**Washington State
Department of Transportation**

February 5, 2014

Subject: DNS 14-005: Yakima Highway 10 Access
SR 10 milepost 101.1 right

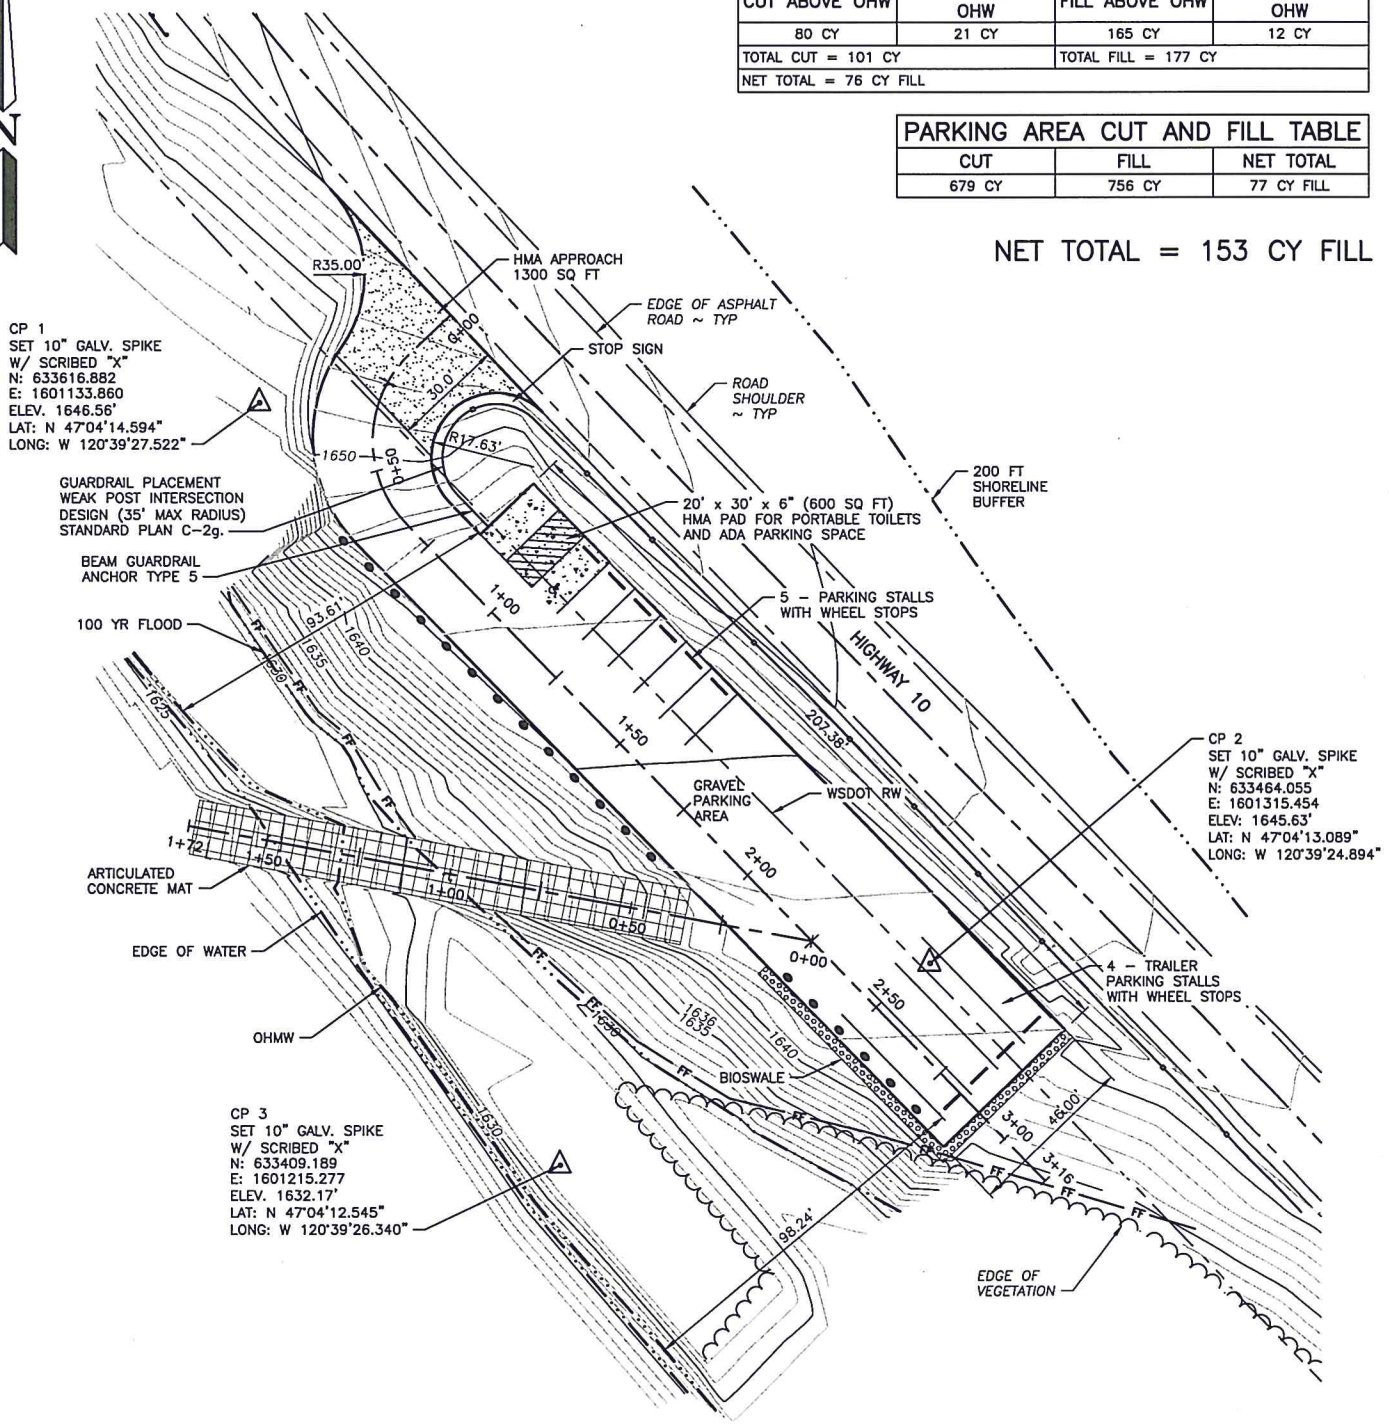
- The parking lot configuration shown in the review documents has been significantly changed from the conceptual considerations. WSDOT has concerns with placing new features, including parking stalls, within clear zone. The previous parking configuration reviewed by WSDOT is more suitable for avoiding clear zone issues and mitigation. The proponent is required to contact this office to discuss the geometrics of alternate solutions.
